Date: 24 July 2018

Application by Norfolk Vanguard Limited for an Order Granting Development Consent for the Norfolk Vanguard Offshore Wind Farm

Advice Following the Issue of Decision to Accept the Application for Examination

Title: 2.7 Plan showing streets to be temporarily stopped up (sheet 20 of 42)

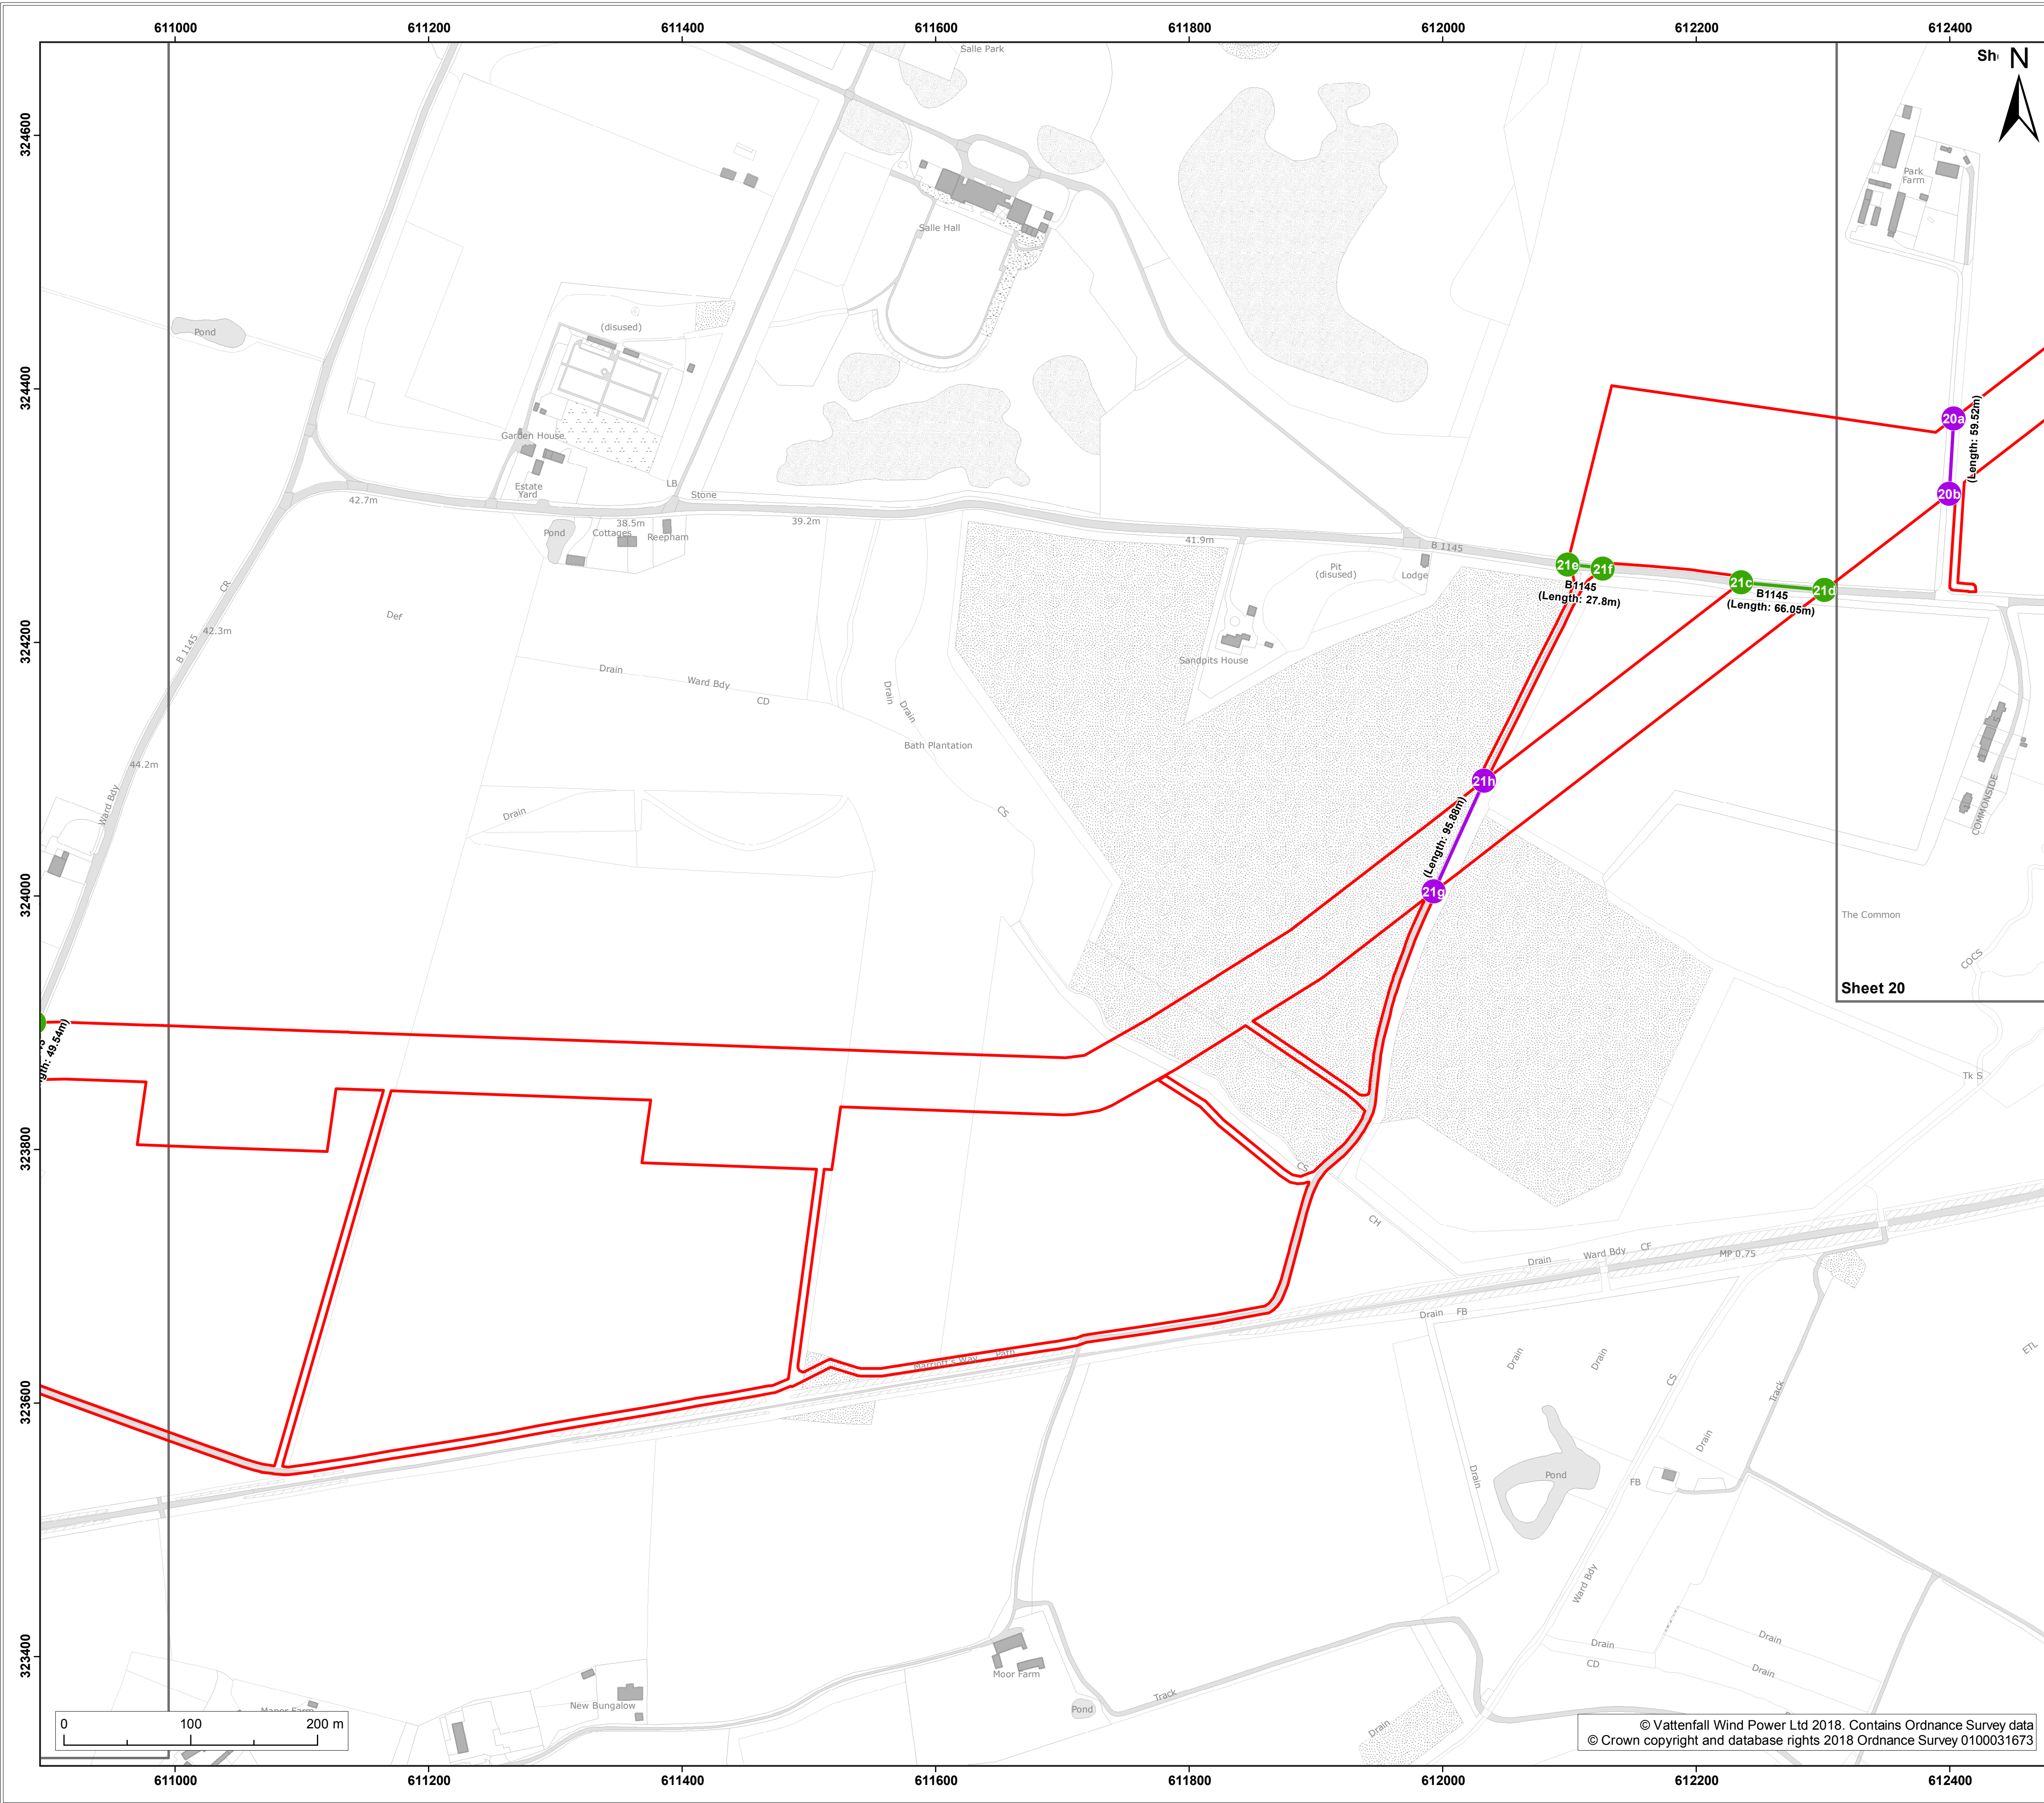
- Sheet 20 of 42 of the plan showing streets to be temporarily stopped up (Doc 2.07) illustrates the stopping up of an unidentified private road 59.52m in length between '20a and 20b'. However, Schedule 4 of the draft DCO does not have a listing for this description.

- There is also a duplicate listing for the stopping up of Oulton Street for approximately 70m between "20a and 20b", which is not illustrated on sheet 20 of 42 of the plan (Doc 2.07).
